ABNORMALS COMMENTARY

**DEVELOPMENT OF LAND OFF HORSESHOE
ROAD, SPALDING, LINCOLNSHIRE**

CP VIABILITY

SEPTEMBER 2025

Drawn	RM	Date	20-03-2025	Proj. No.	768/24
Chkd	RM	Scale	As shown	Dwg No.	LS01

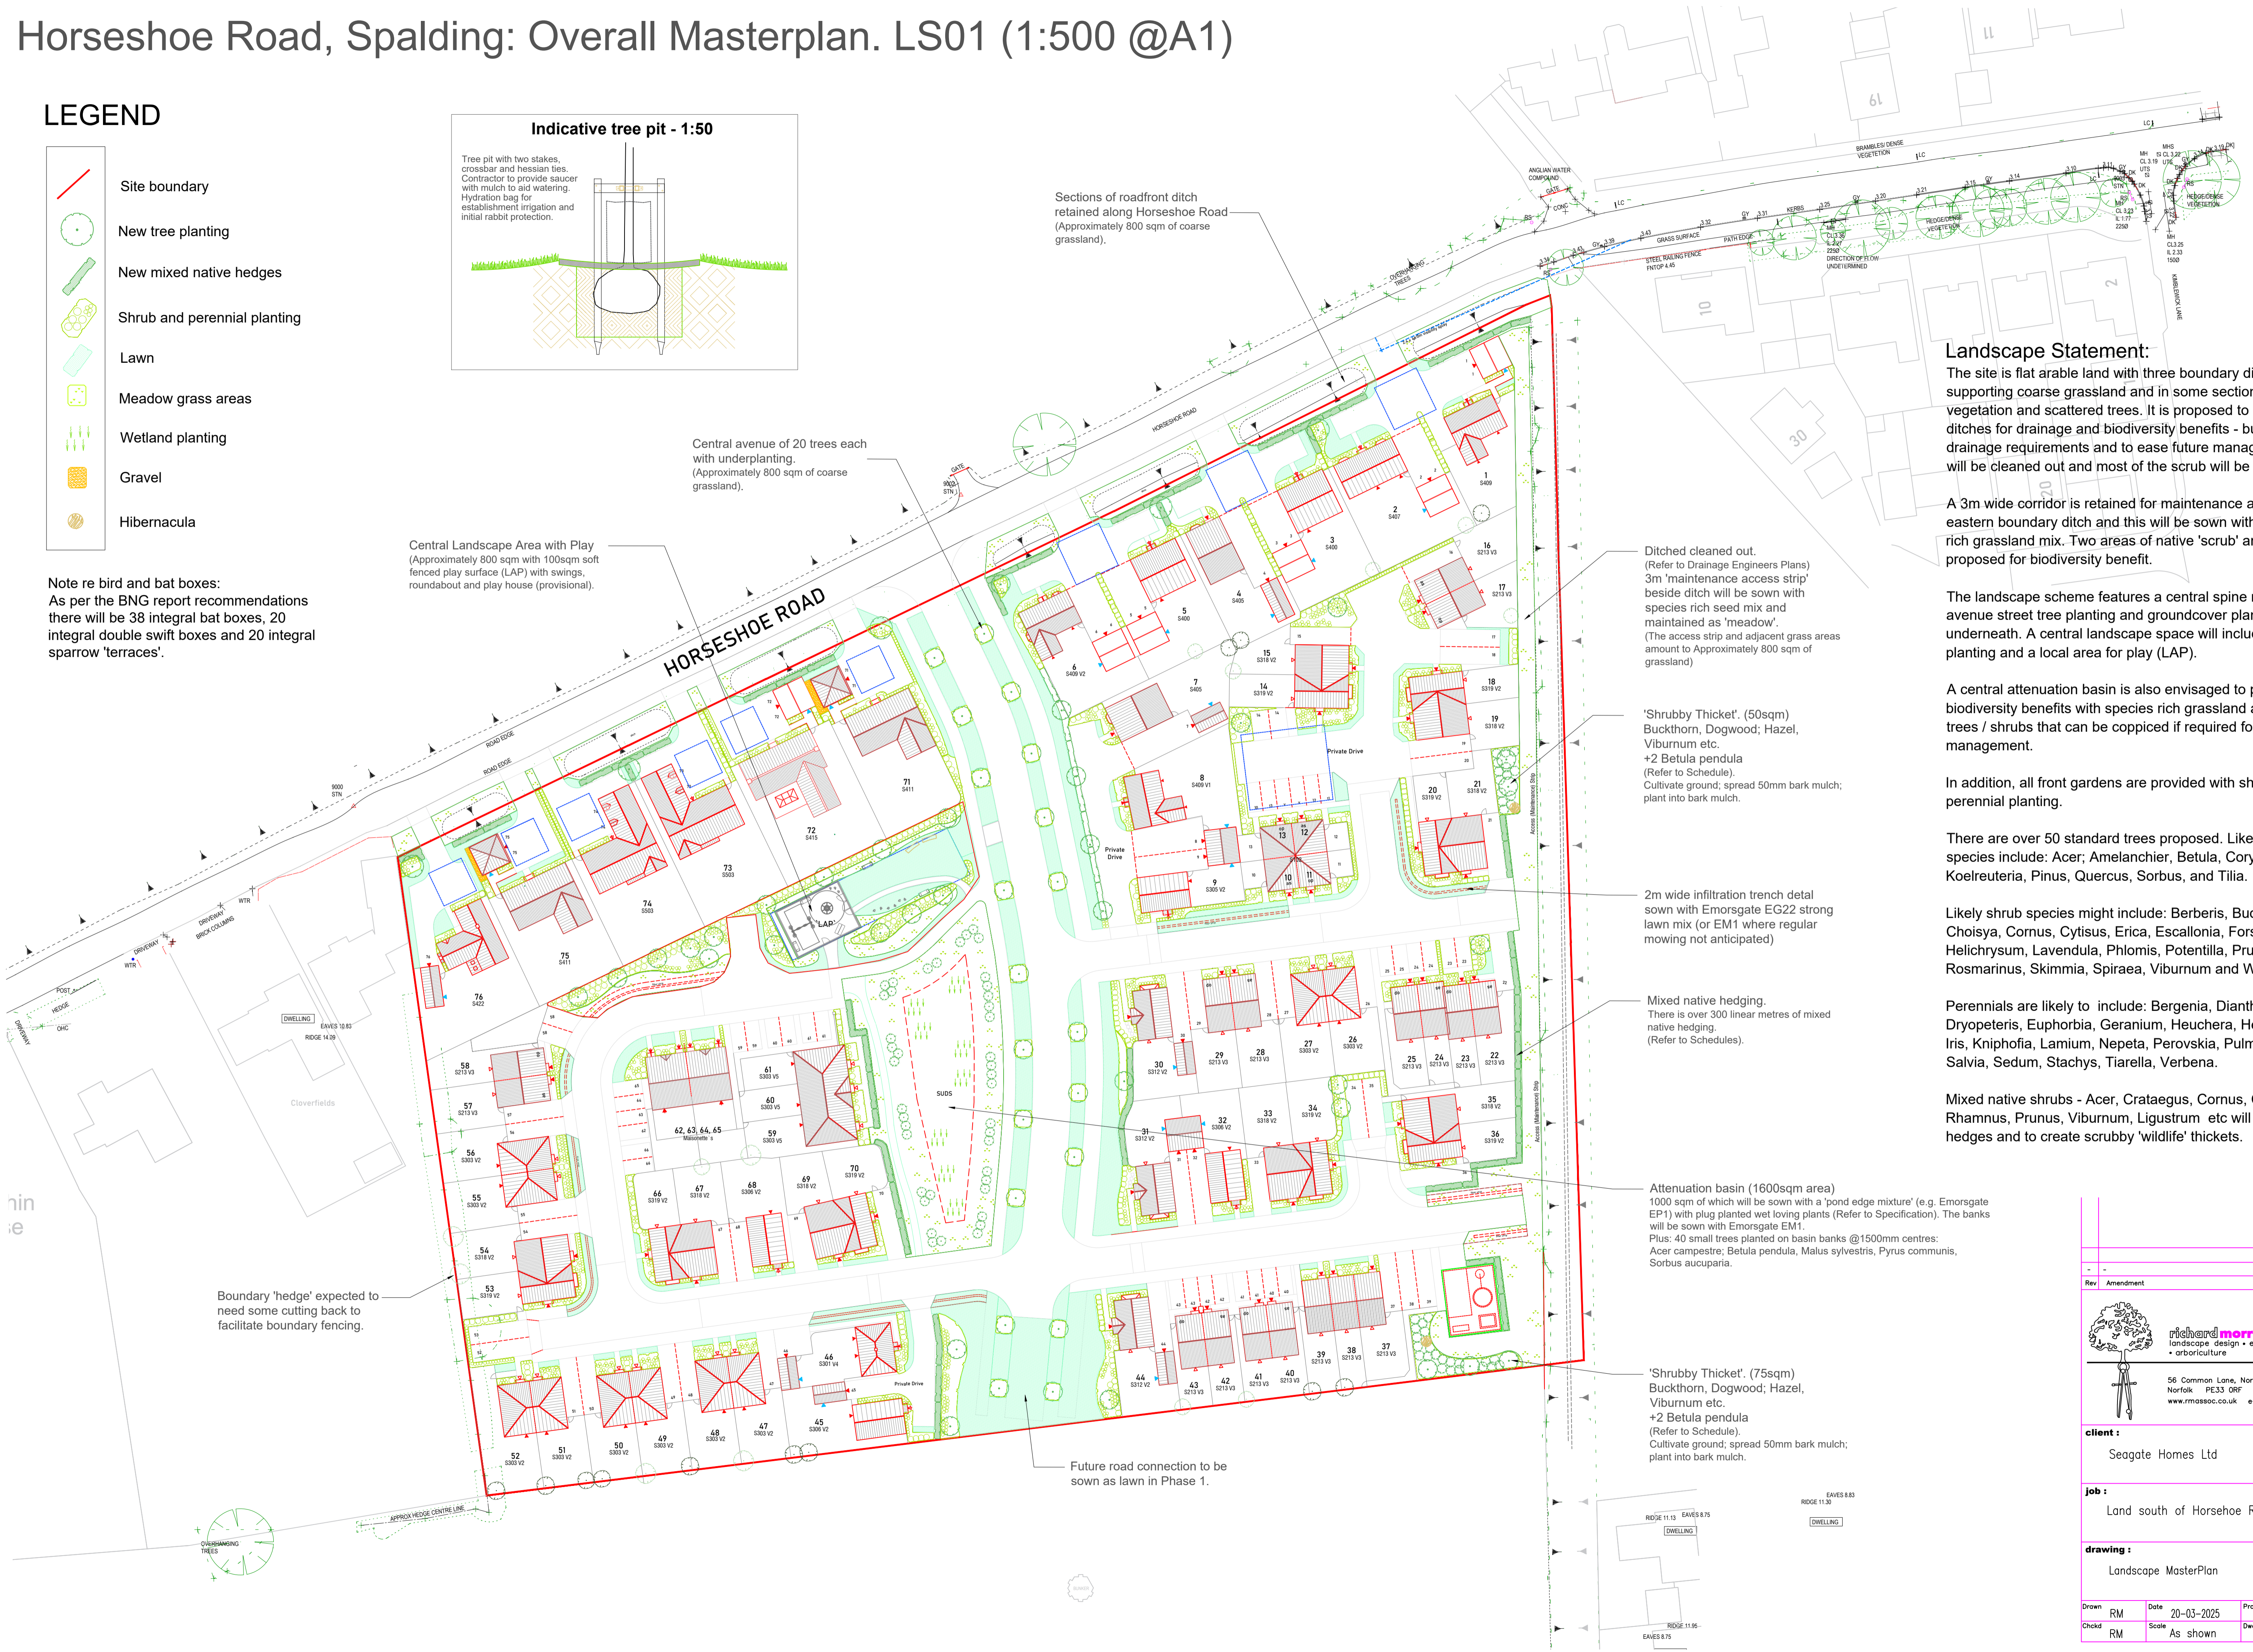
Lump sum allowance of £2,000 for 38 Nr bat boxes (as shown on Landscape Masterplan).

A cost of £52.63 each allows for install of a basic bat box and are happy to agree this figure.

The surfacing allowance is for wet pour and based on a quantity & rate, for which we scale-measure the area as 102 m². We are happy to adopt the rate of £136.00 used in the FVA.

We assume the 50 m overall length allows for a square enclosure around the LAP and we have scale-measured this to be acceptable.
